Sydney Catholic Schools

#### Re: Marist Catholic College North Shore (SSDA-10473)

We refer to DPIE letter dated 20.12.2021 Response to Submissions and SDRP Third Review in response to State Significant Development Application for Marist Catholic College North Shore and specifically comments raised in relation to the Architectural design.

#### **RESPONSE TO DPIE**

Title
EXISTING AND DEMOLITION PLAN
- GROUND LEVEL

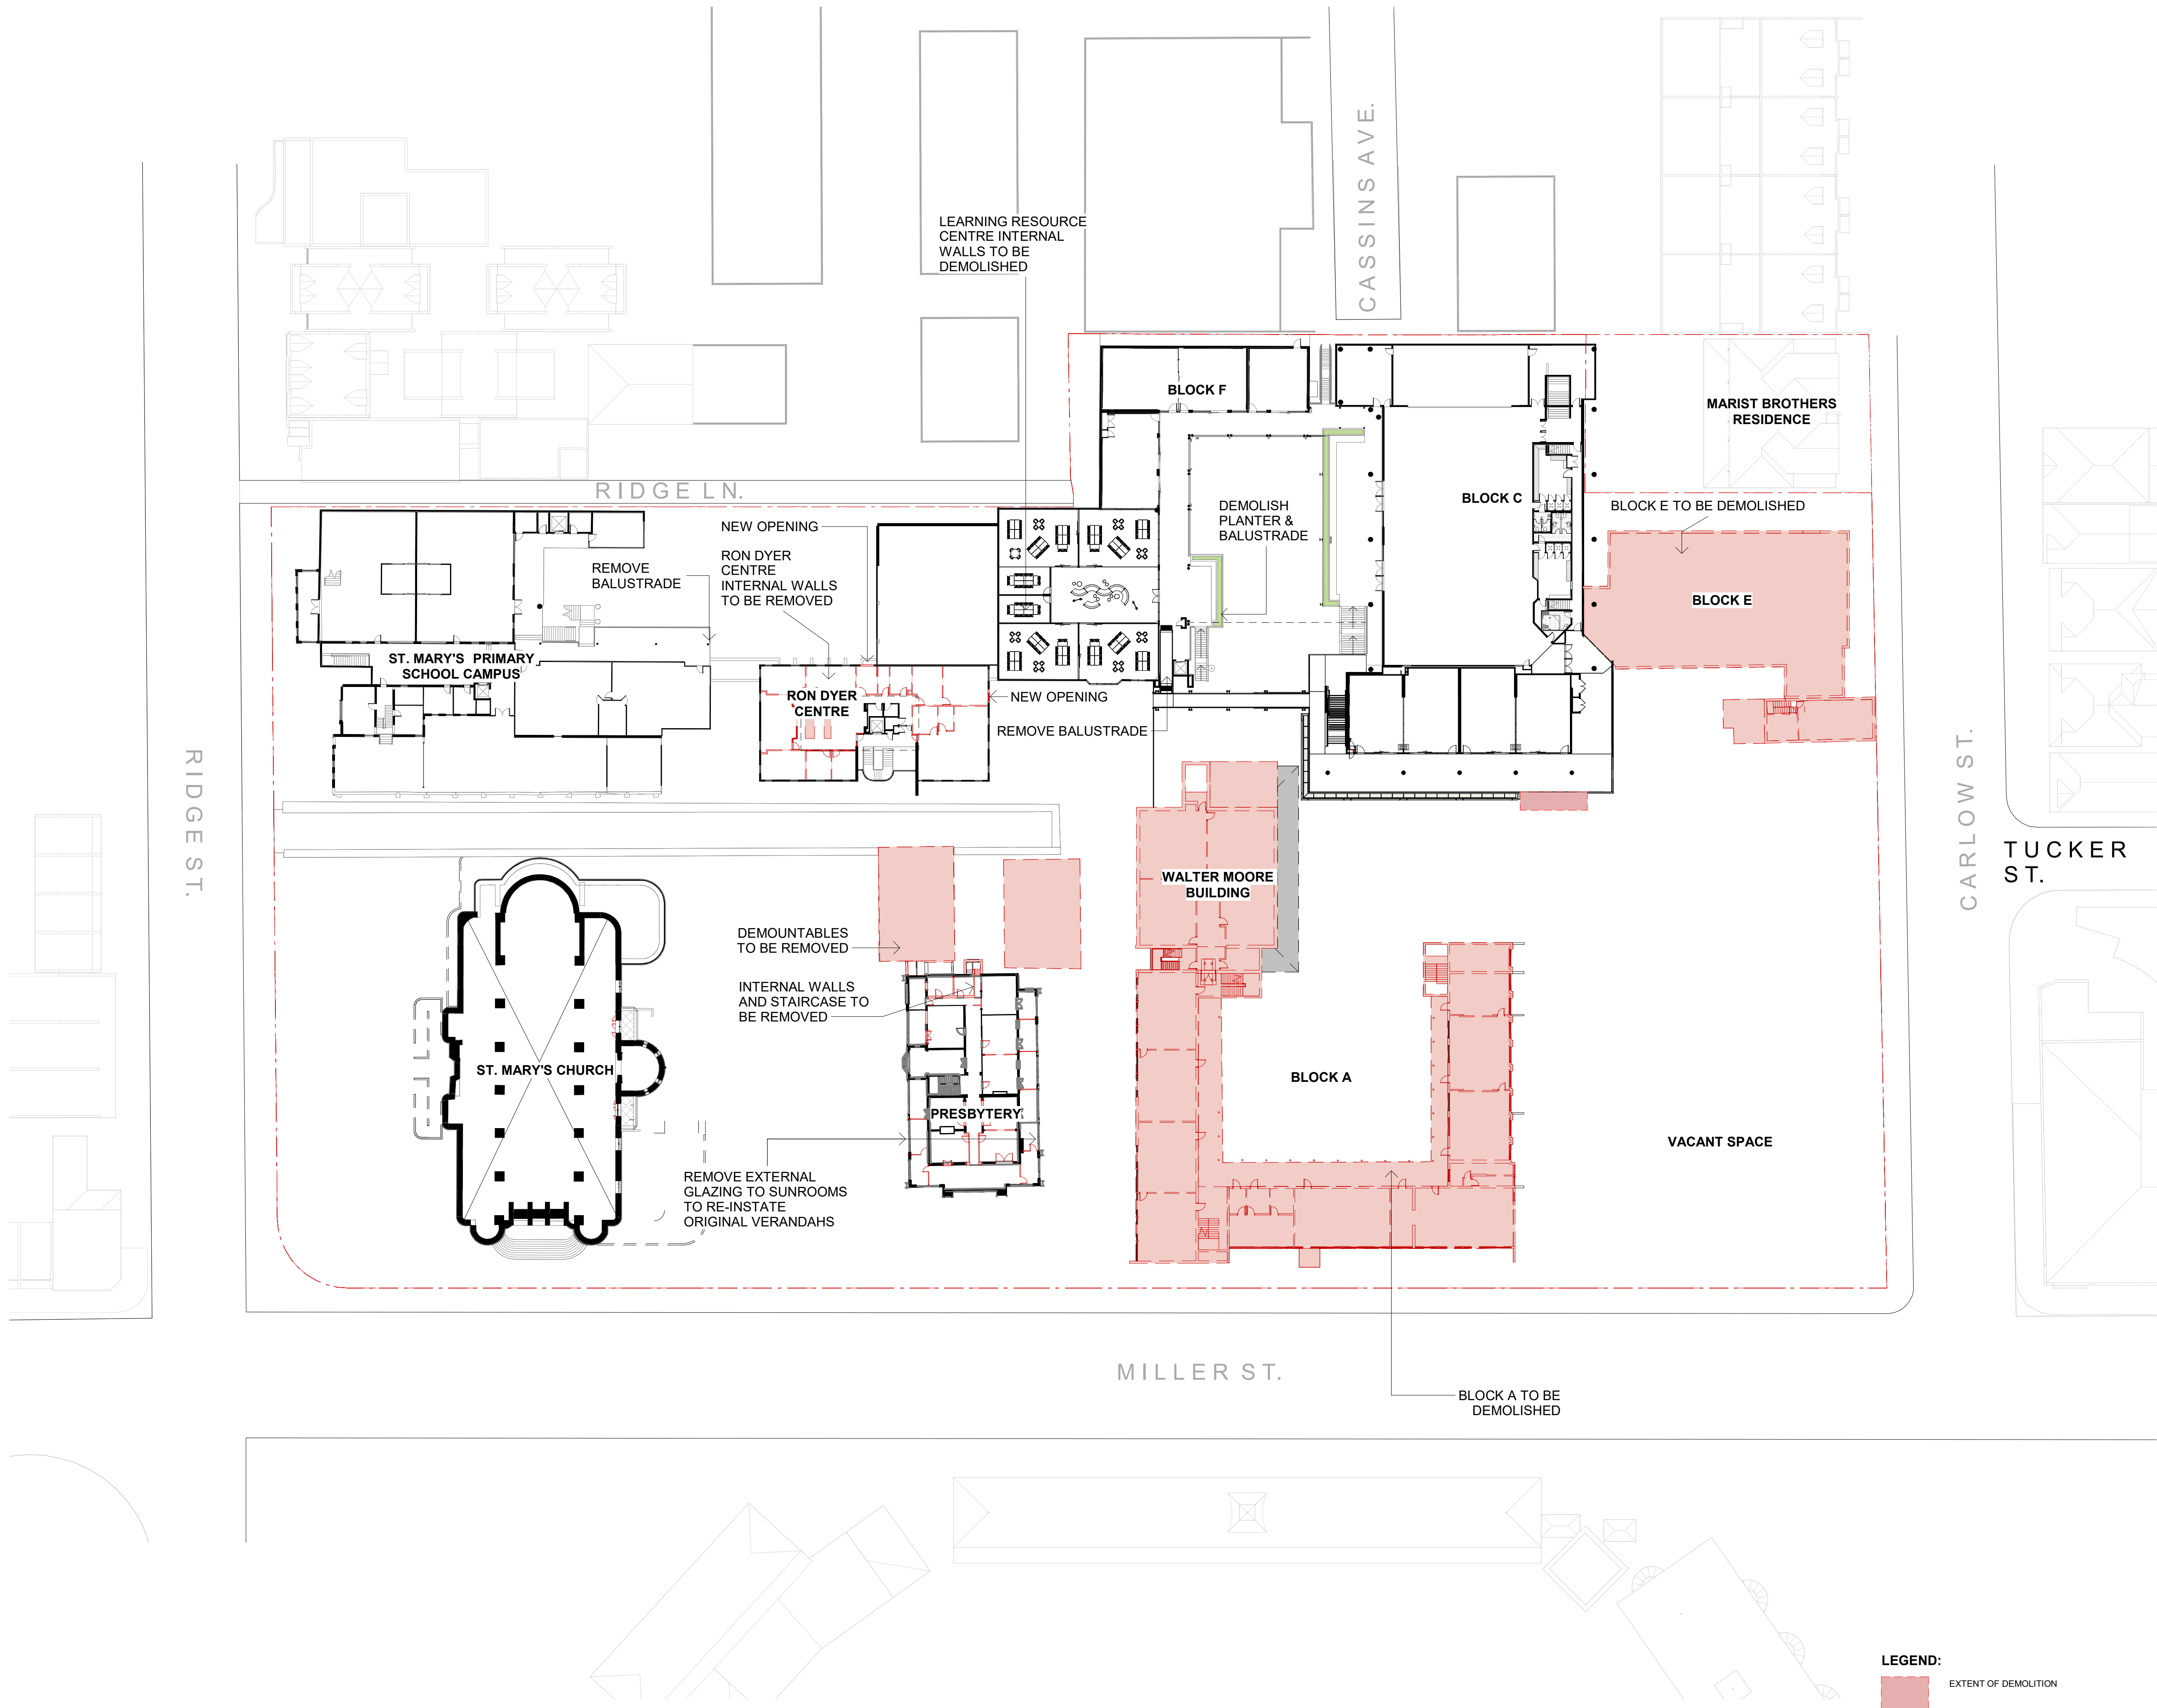
Demolition Plans	
The demolition drawings continue to show the two terraces, Jacaranda Cottage and other site preparation demolition works for which separate Council DA approval has been granted (DA100/21) and no longer form part of this application. Either remove these works or include a clear annotation with colour change confirming separate approval has been granted for these works and they do not form part of this application. The demolition drawings include an annotation that that demolition of Block C Annex "Note: Proposed development subject to separate approval". This being the case, remove the demolition drawings.	Refer to DA-010 and DA-011 - Demolition Plans Demolition plan has been updated to reflect existing conditions on site - the terraces and Jacaranda cottage have been removed. Block C annex demolition has been removed and Stage 02A is now shown as existing.

Title
GA PLAN - BASEMENT ZONE 2

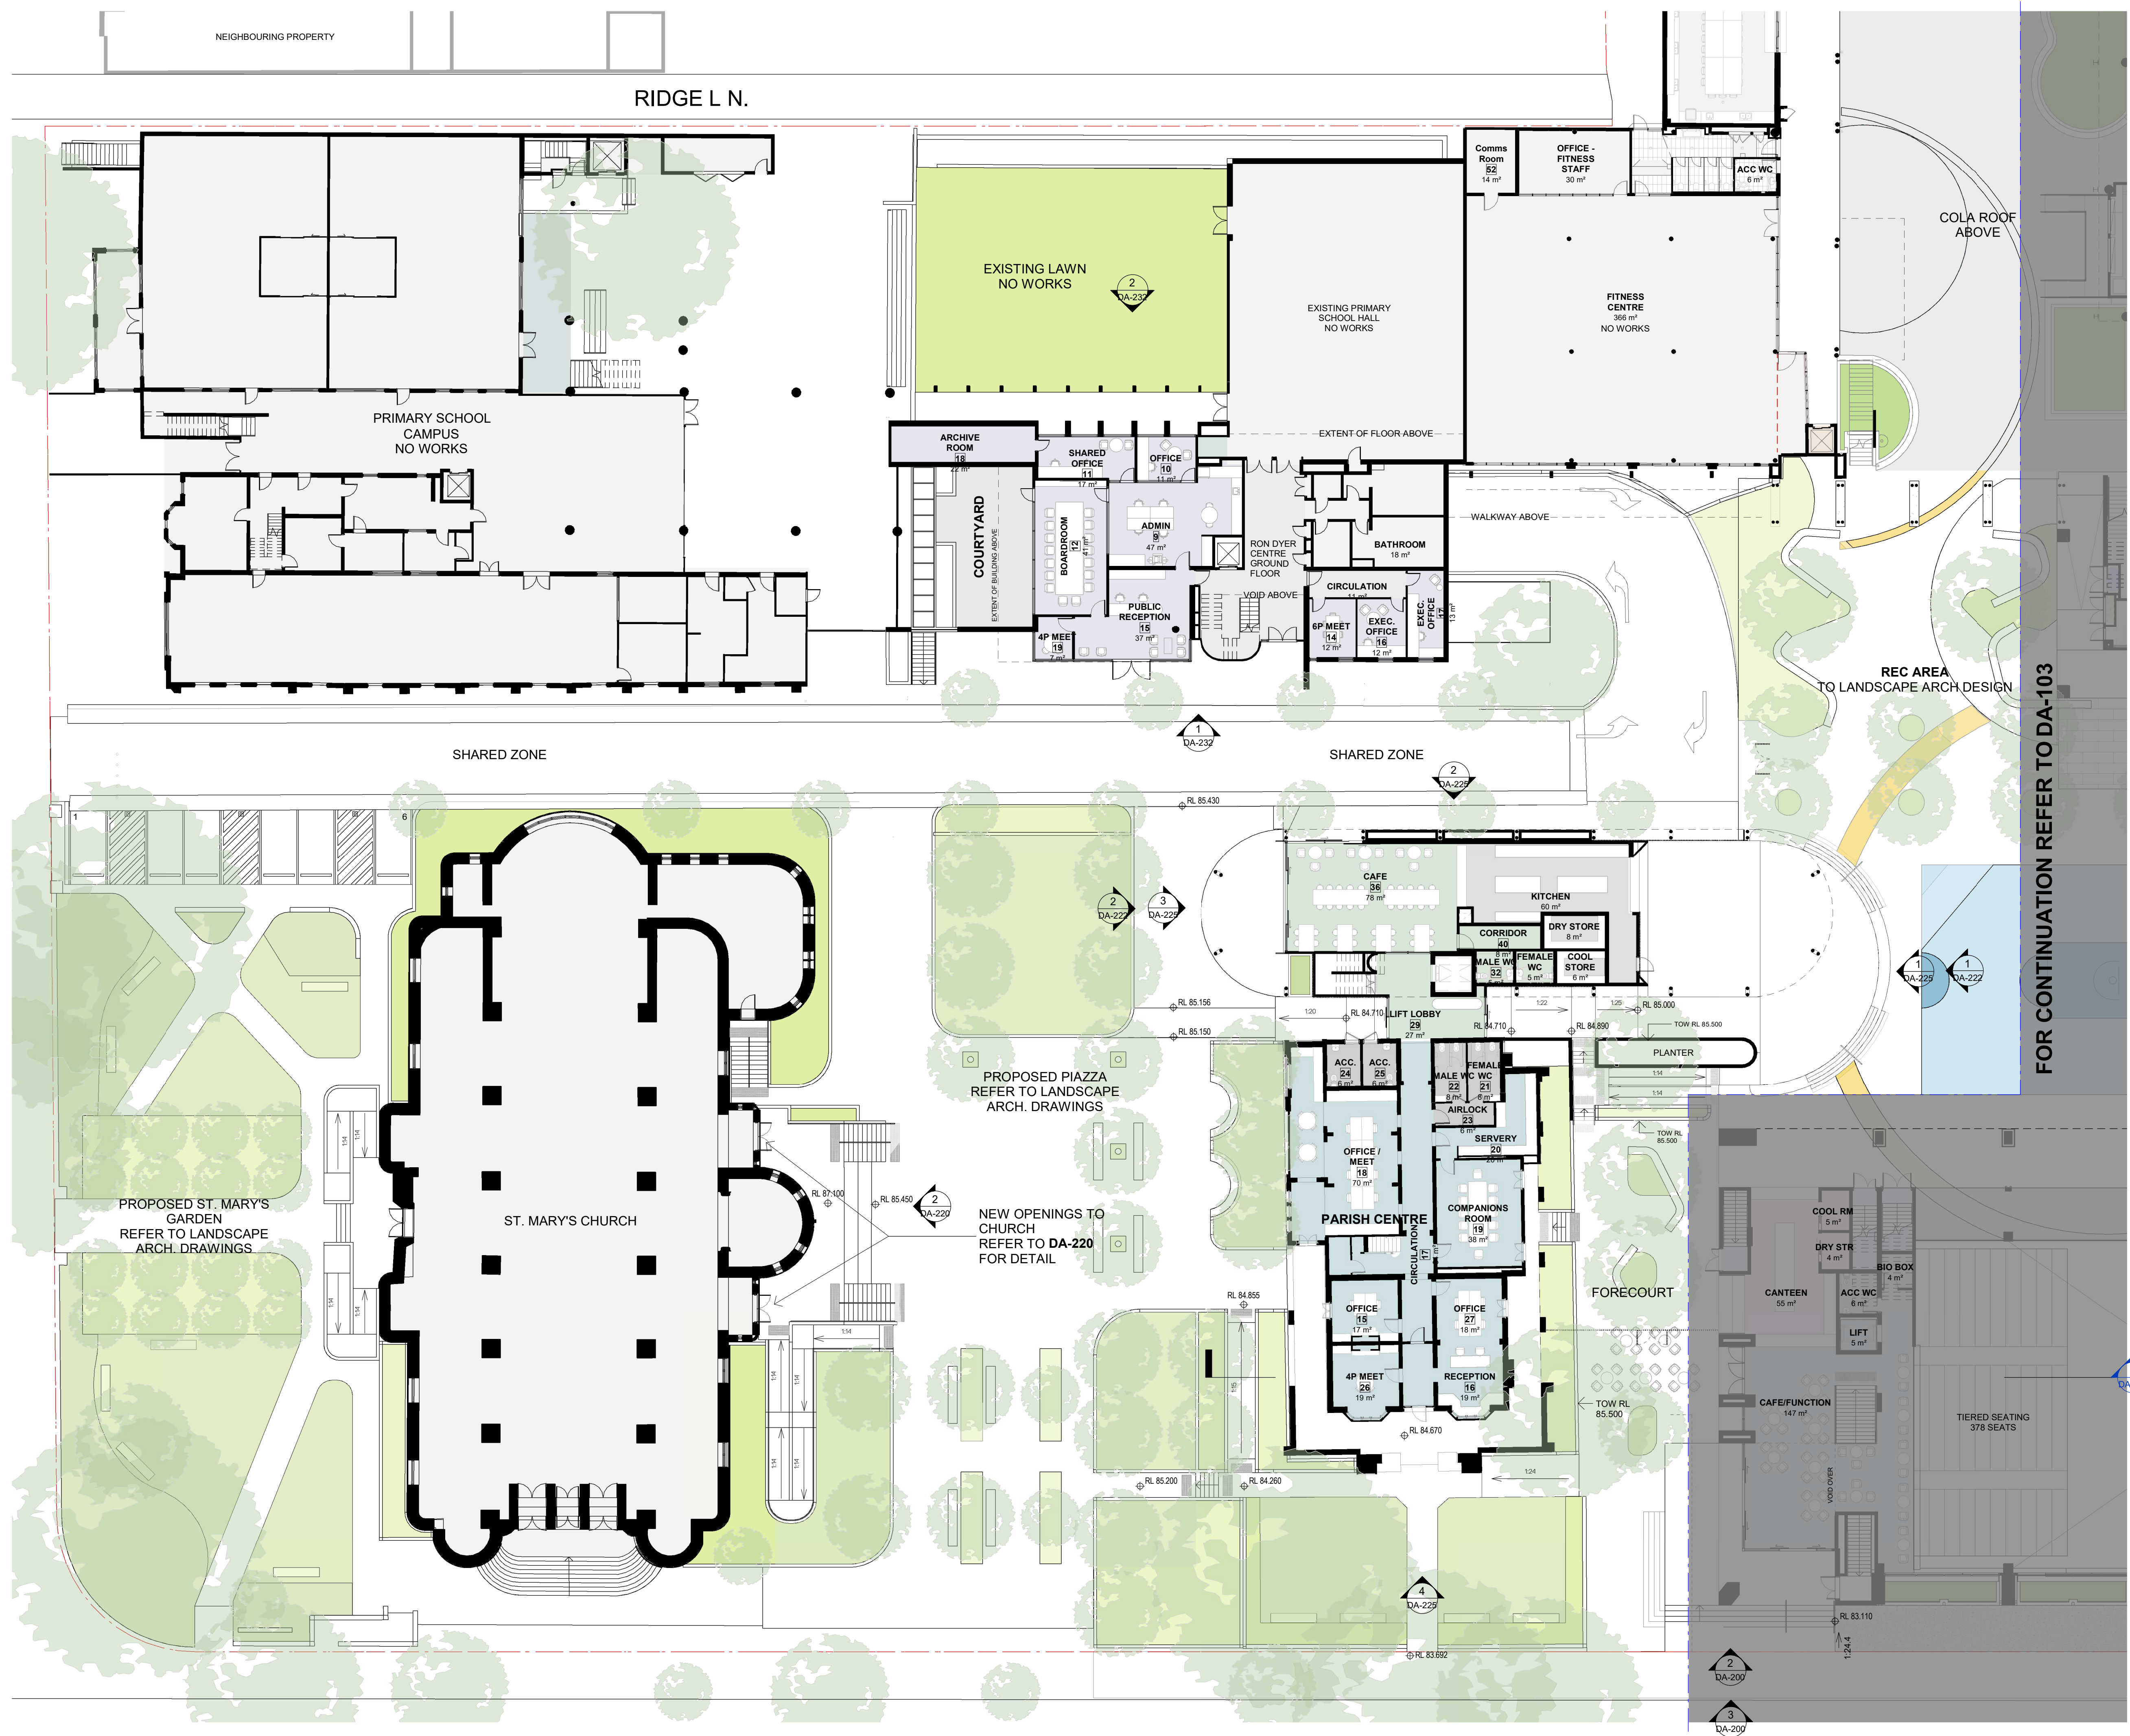
Provide a secure lobby space between the lifts and the entrance to the child care centre in order to enable controlled access.	Refer to DA-101 -GA PLAN - BASEMENT ZONE 2 and DA1-5 - GA PLAN - LEVEL 1 ZONE 2 A dedicated lift to the childcare has been provided to control the access to the

learning floor. This lift cannot access any other floor apart from the Child Care and the Miller St. entry and vice versa. Furthermore, a secured, dedicated lobby has been provided for this lift as an additional secured line for children exiting the lift. Please see Appendix F - Traffic and refer to Deliver a safe and effective pedestrian and vehicular traffic strategy and demonstrate Transport Impact Assessment (by others) how the shared zone will be used at dropoff/pick-up times and during school hours. There is a conflict between students using the proposed shared zone and vehicles entering and exiting the Ron Dyer Centre basement carpark.
